**Dunnet Properties Pty Ltd**  
Suite 15,  
20 Young Street  
Neutral Bay NSW 2089

15 December 2022

**SSD-35283699 – Submission**  
**Sydney Olympic Park Metro Station Over and Adjacent Station Development**

3.2 Winter Solstice

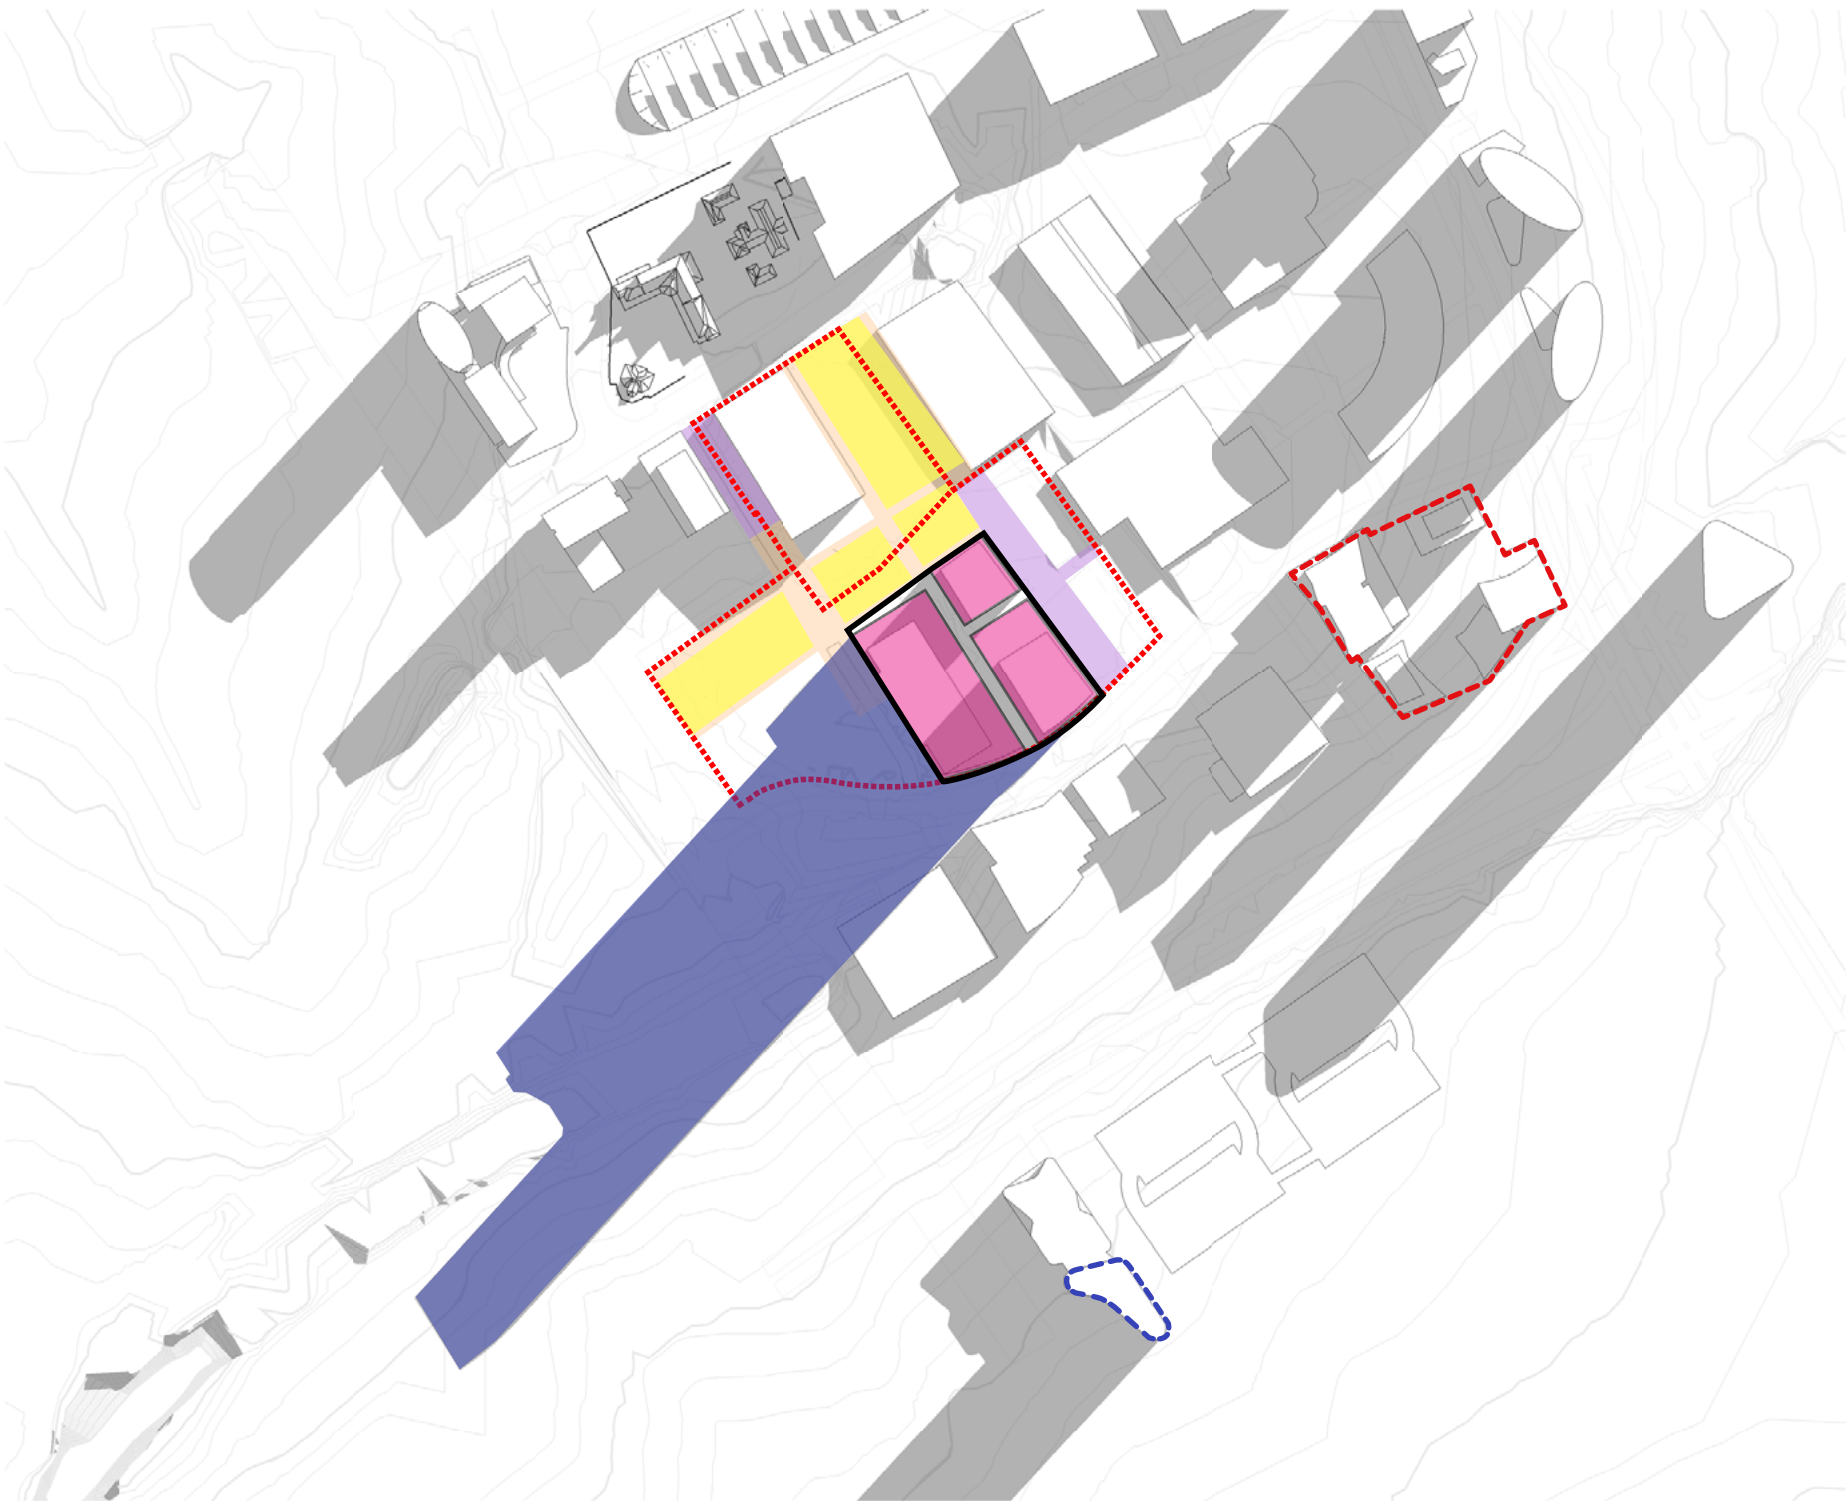
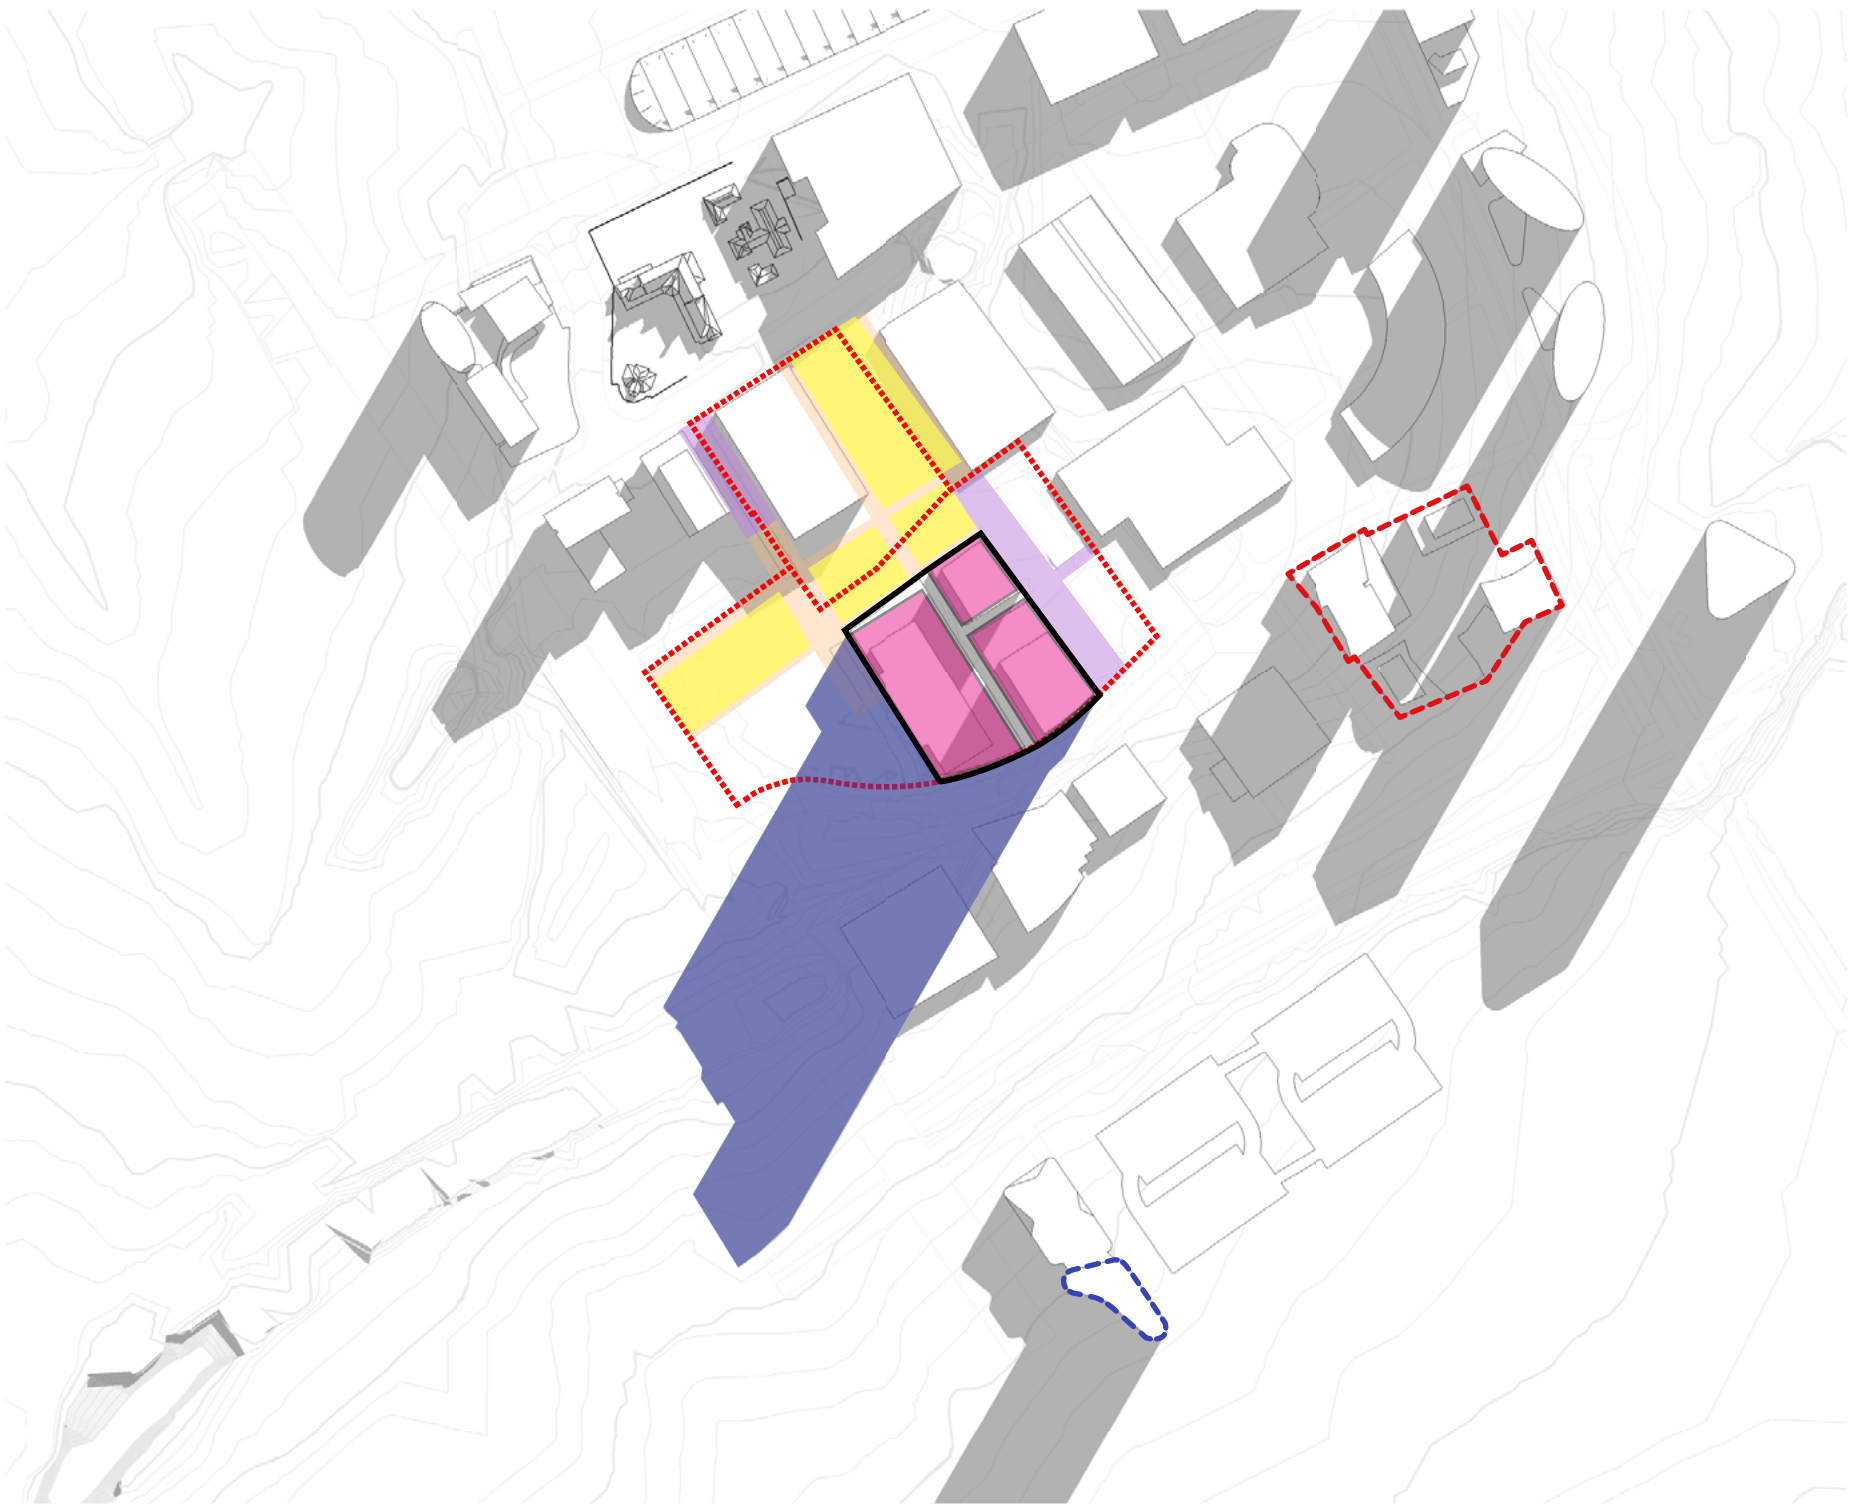
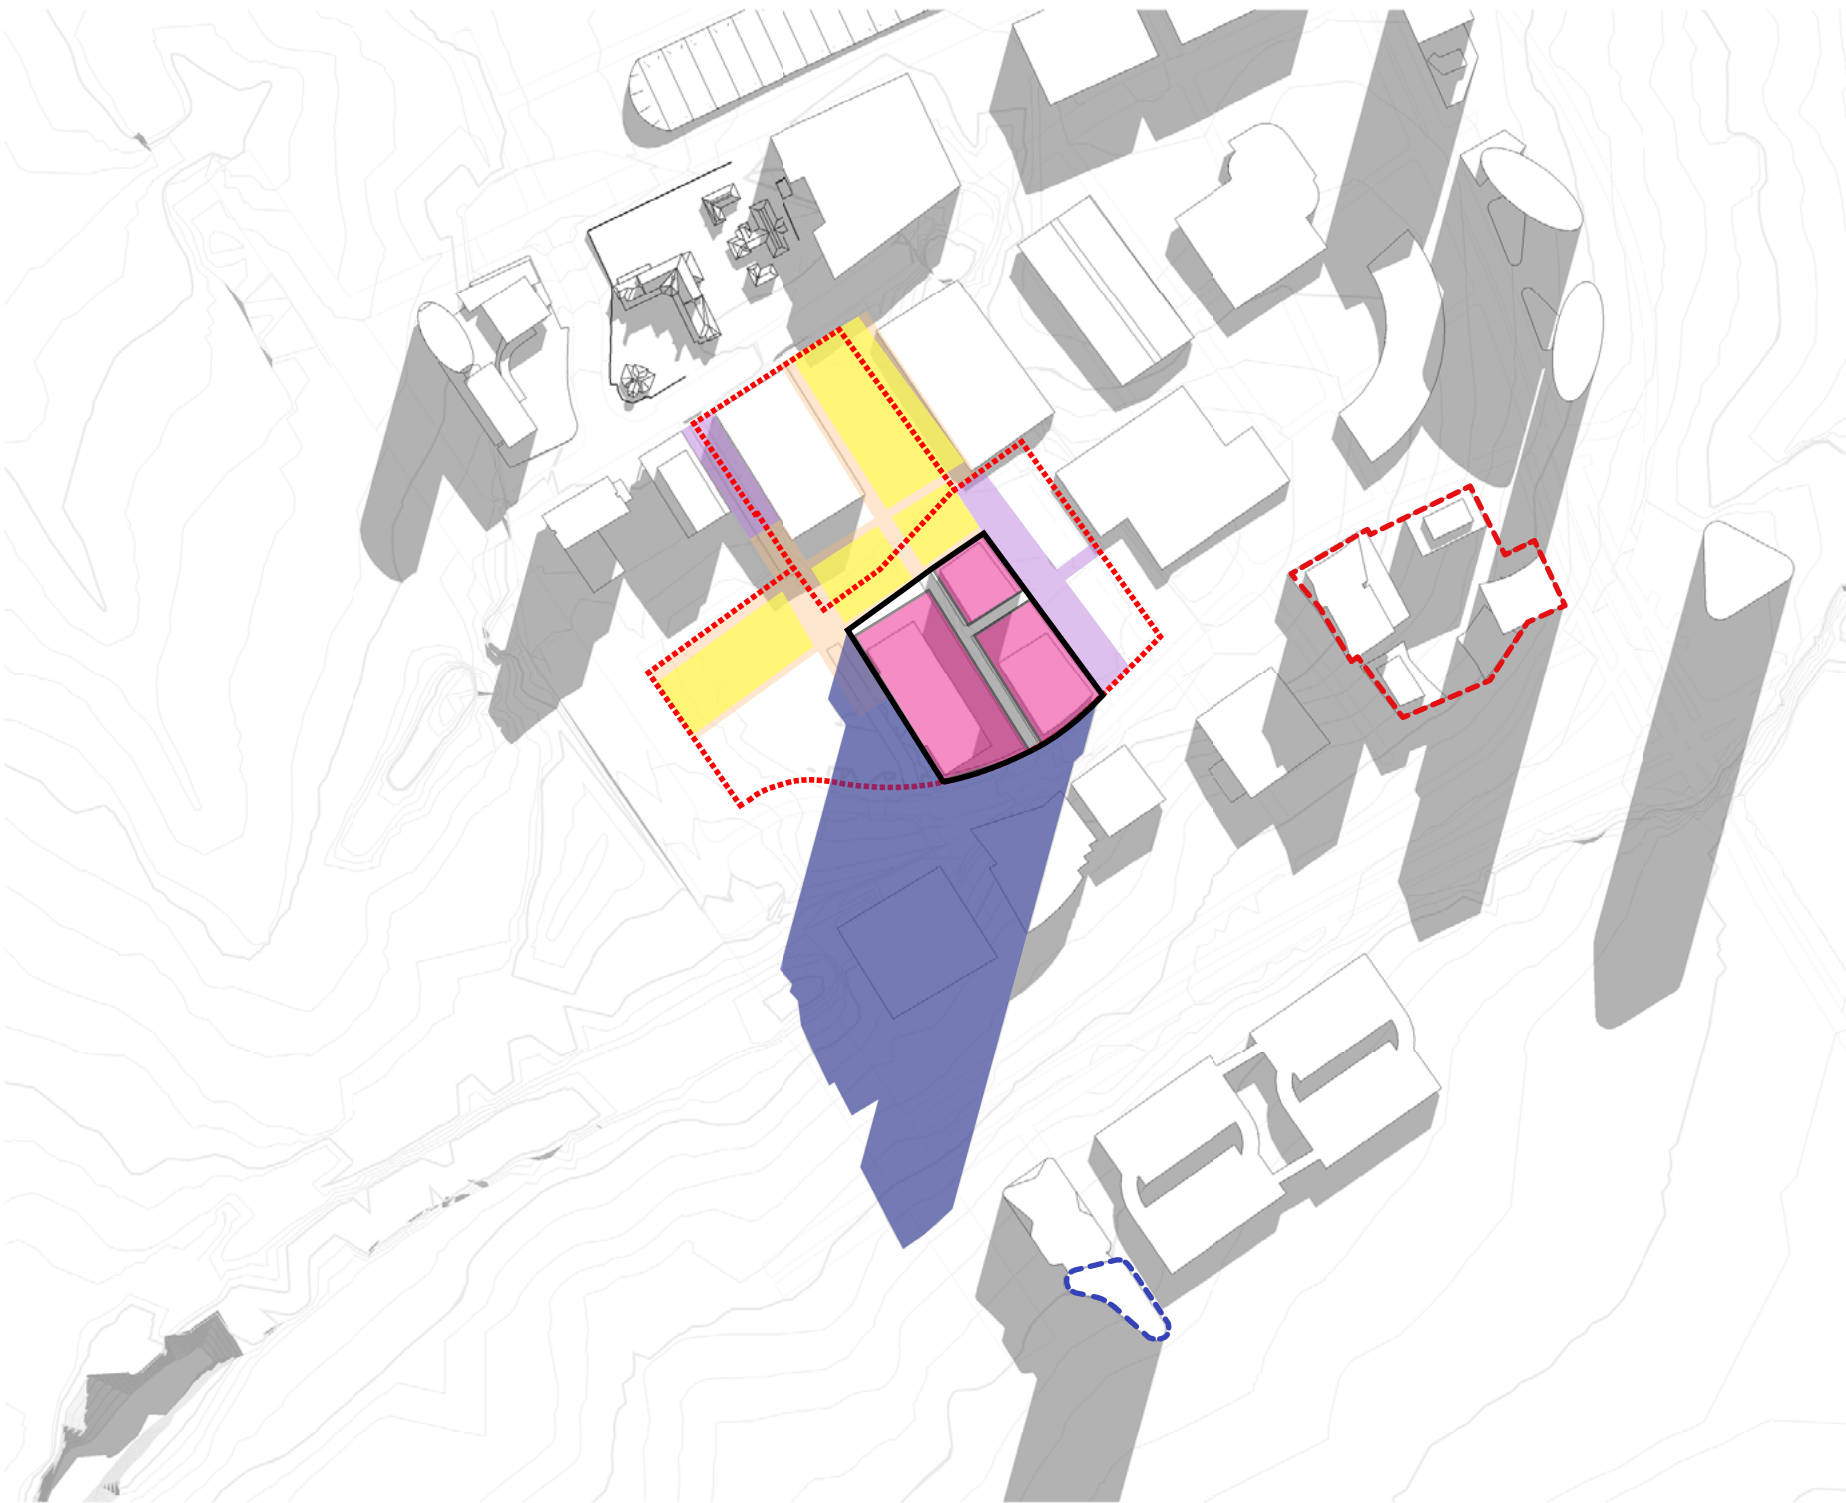
The proposed SSSA will result in significant overshadowing of Site 50 on the winter solstice from 9am through to 1pm, with vast impacts from 9am through to 12pm. This is demonstrated in the below extracts of the overshadowing diagrams submitted with the SSSA included at **Figure 2** below.

The cumulative shadow impacts caused by the proposed Concept SSDA and the future development on Site 48 will detrimentally impact the development potential of Site 50 in terms of maintaining acceptable levels of solar access to the podium and towers. This is especially harmful to the development potential of Site 50 given that the site is envisaged to be mixed use including significant components that will likely comprise a residential use. As such, given the significant all day cumulative overshadowing expected as a consequence of the Interim Metro Review of Site 47 and 48, further work is considered necessary for the Concept SSDA to mitigate the overshadowing impacts on Site 50.

Figure 40: Proposed building envelope heights (Building 1)

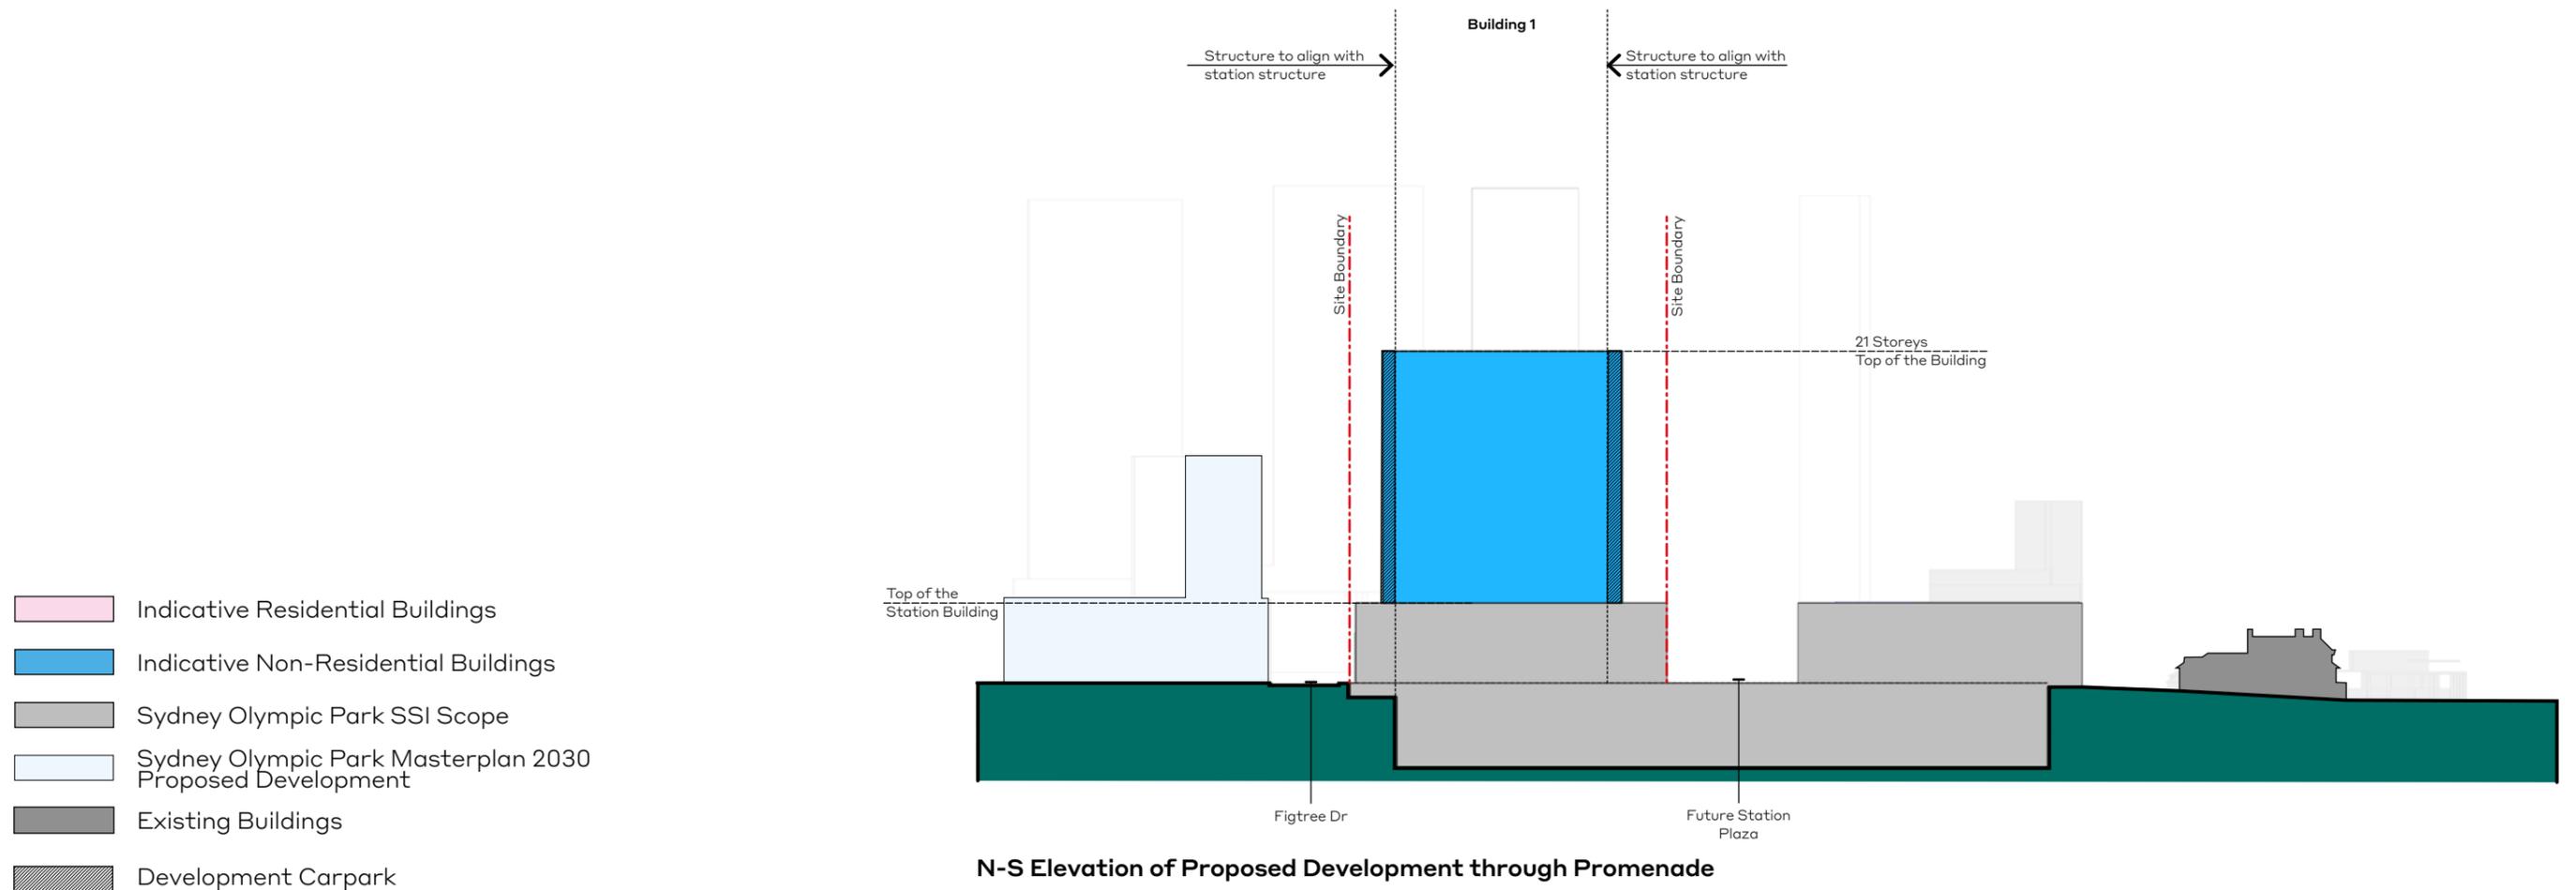
As a result of the abovementioned shadow impacts that will be caused by the proposed SSDA, and the cumulative impact when also considering Site 48, it is strongly recommended that a sun access plane be adopted for Building 1 contained within the proposed Concept SSDA. The sun access plane is recommended

for this building given its proximity to the site, and the vast 63.75m width of its tower form which results in considerable shadow impacts on Site 50 that would impact its development potential.

This sun access plane should be suitably designed to minimise overshadowing of Site 50, in accordance with the recommended sun access plane designed by Curzon + Partners, which will be submitted under a separate cover. Dunnet Group recommends that the sun access plane either be included as a condition of consent for the proposed Concept SSDA on Site 47, or alternatively it could be embedded as design guidance with associated objectives in the Design Guidelines included at Appendix M of the SSDA.
